A46 Newark Bypass

Statement of Common Ground with Think Again A46 Winthorpe Action Group

**Statement Of Common Ground with
Think Again A46 Winthorpe Action Group - TA**

Version	Date	Status of Version
Rev 0	October 2024	Deadline 1

DRAWING NUMBER HE551478	ORIGINATOR SKAG	VOLUME HGN	PROJECT REF NO. HE551478
CONWI_CONW	DR	LE	00004
LOCATION	TYPE	ROLE	NUMBER
			C01

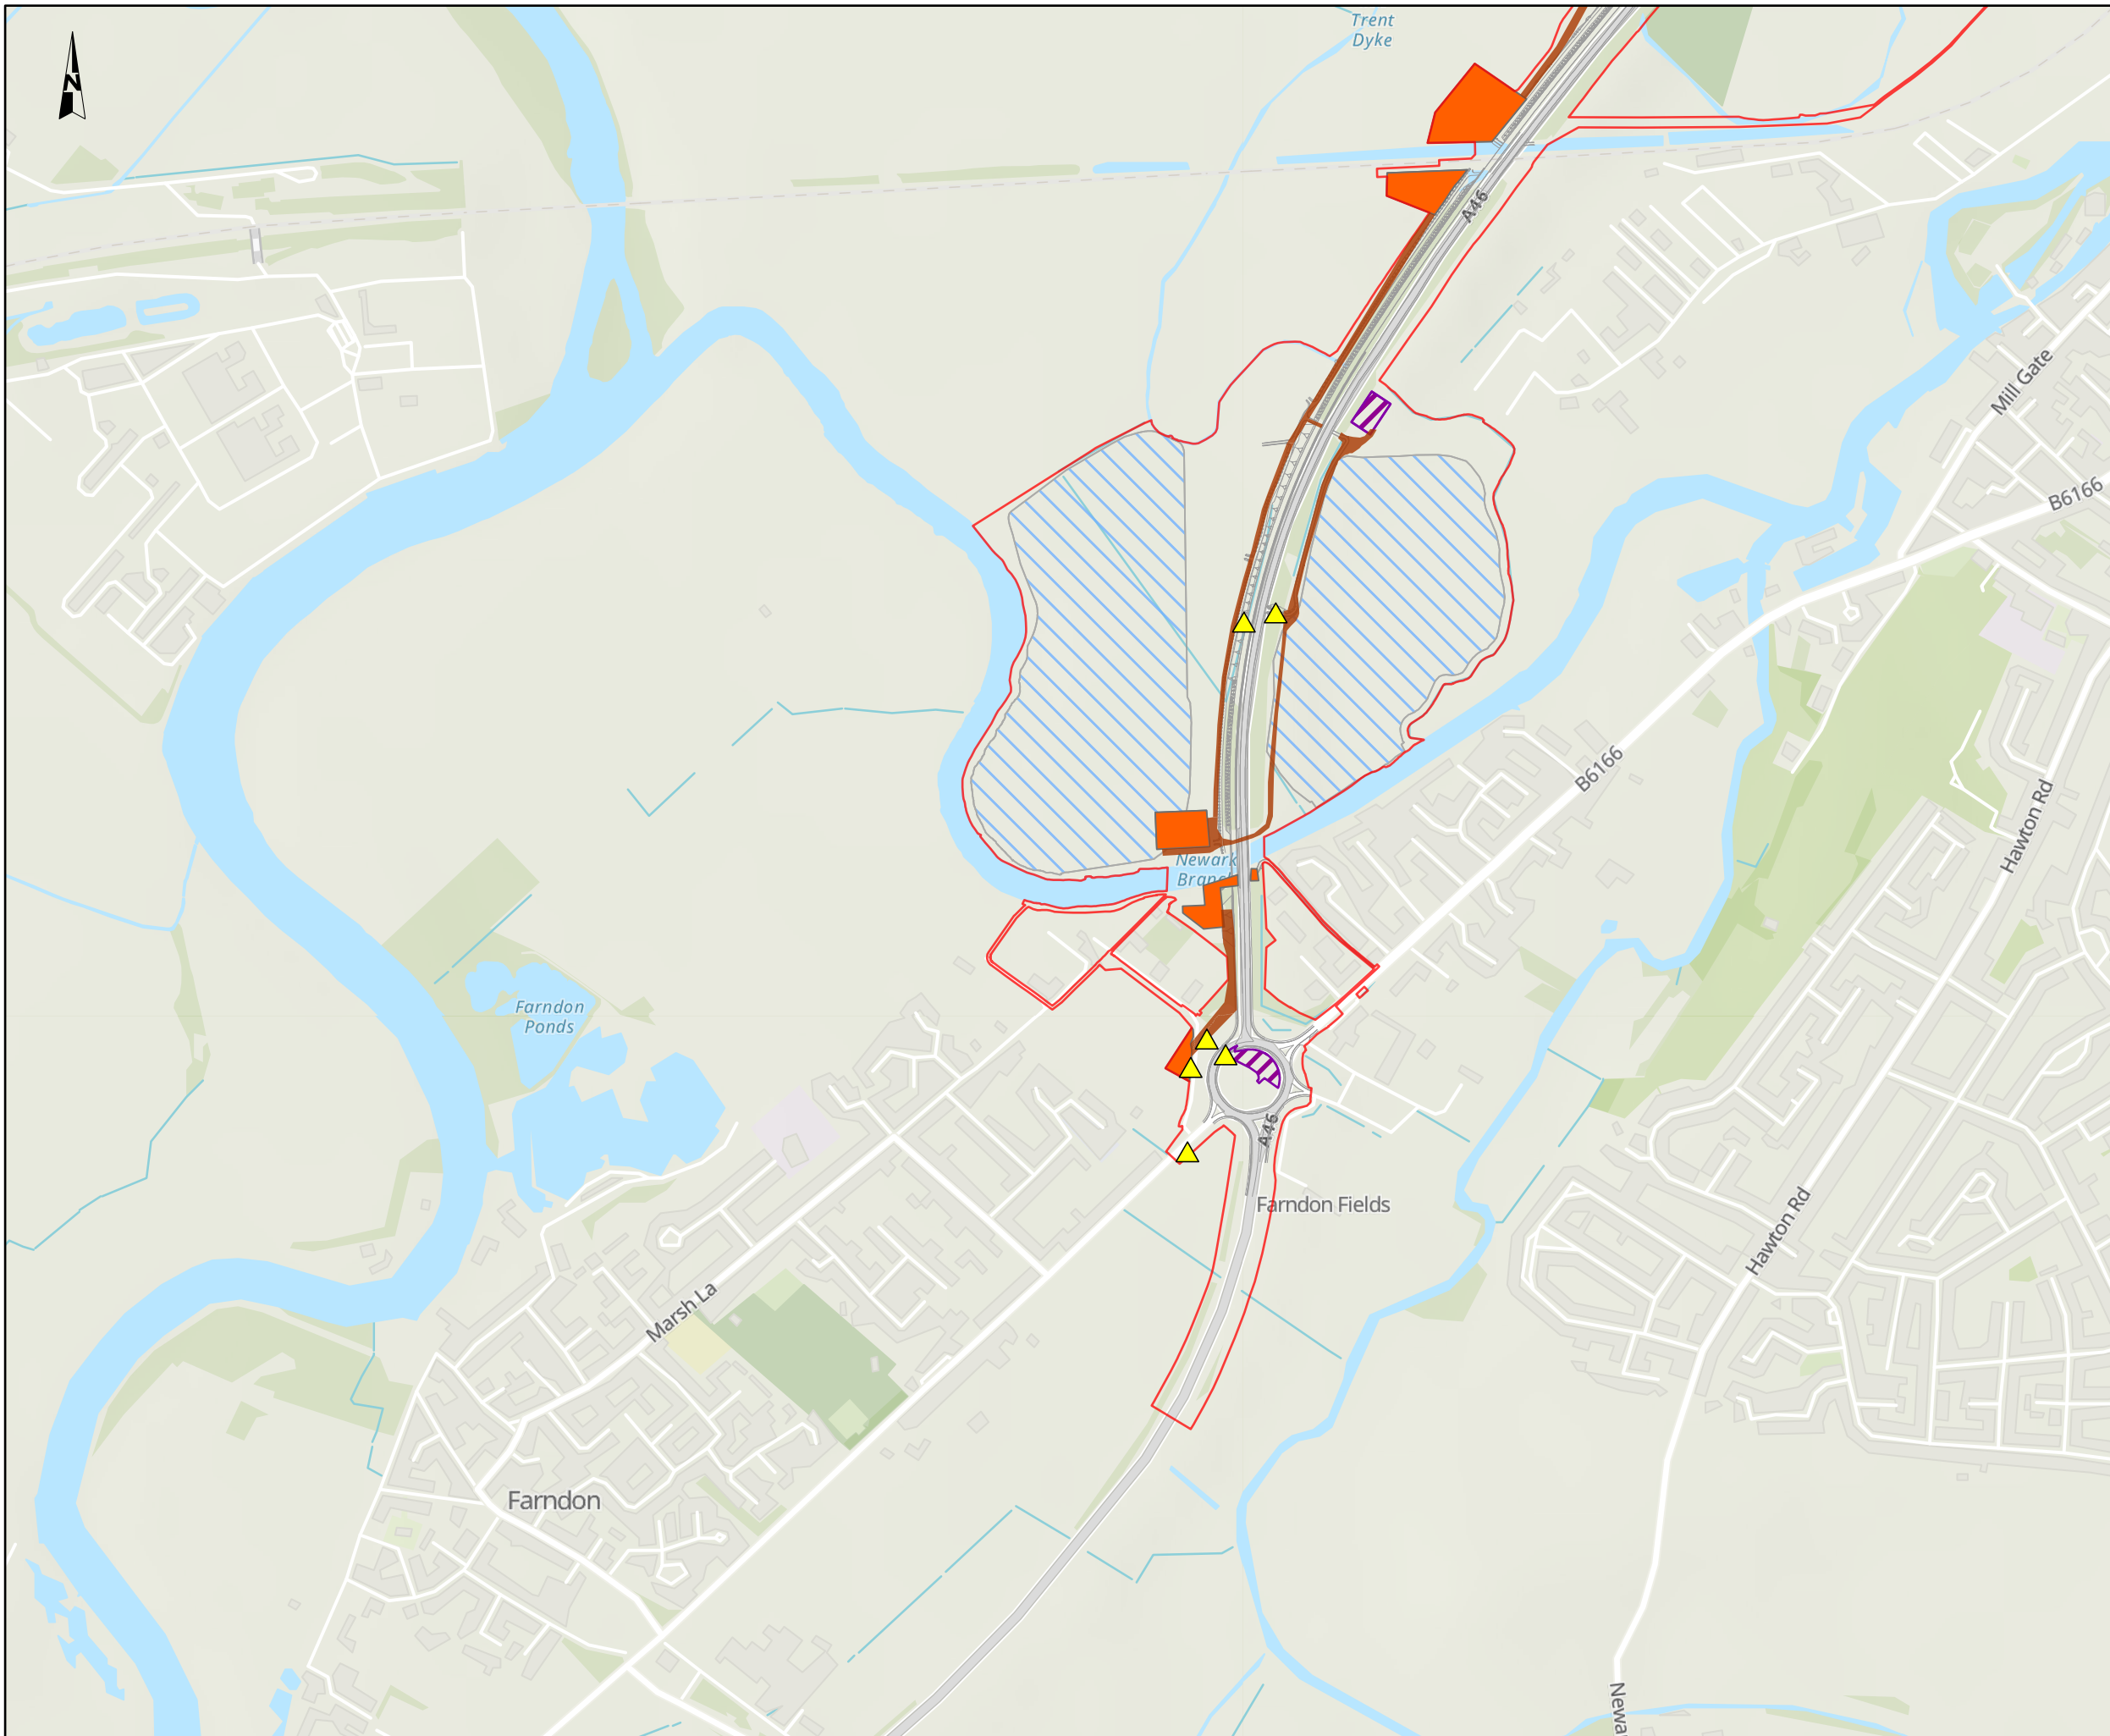
20.	Construction Compounds	<p>Figure 2.4 Locations of Temporary Works Areas Required During Construction of the Environmental Statement Figures [AS-027]</p> <p>Table 2-6 in Chapter 2 The Scheme of the Environmental Statement [APP-046]</p>	What construction compounds and works access facilities will be located in the Winthorpe area?	The location of the construction compounds and works access areas within the Winthorpe area are detailed on Figure 2.4 Locations of Temporary Works Areas Required During Construction of the Environmental Statement Figures [AS-027] and in Table 2-6 in Chapter 2 The Scheme of the Environmental Statement [APP-046].	Agreed	24/09/2024
